Householder Application for Planning Permission for works or extension to a dwelling; Listed Building Consent for alterations, extension or demolition of a listed building

1 Moss Farm

Two storey extension to dwelling and refurbishment of existing cottages to form single dwelling
Following Natalie Drewetts comments we have lowered the height of the walled garden to 1.8m and moved the French doors on the rear elevation slightly to the right.

Drawing N° 109A  
Revised elevations  
Scale 1:100 @ A3

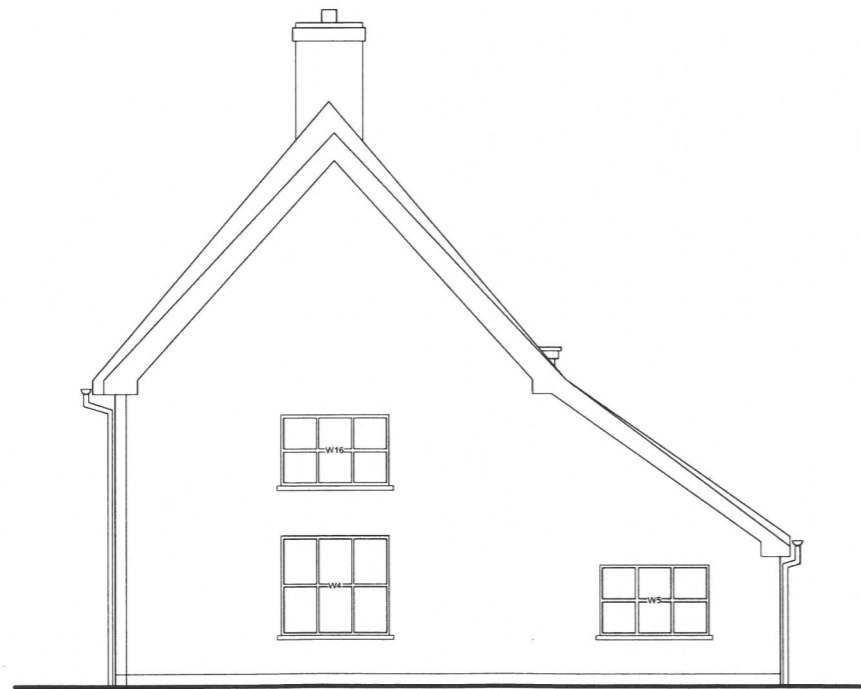
The casement doors look a little too close to the end of the building, so I would recommend that these are moved slightly to the right.

I have been musing about the walled garden. I am a bit concerned that, with the dimensions shown and the 2.1metres eaves height, this could appear like a flat roofed rear extension to the washhouses. I will have a further think on this and get back to you.

we have resubmitted drawing No; 109A (revised elevations) to show windows W01 , W10, W19, & W12 in the same style as agreed windows.
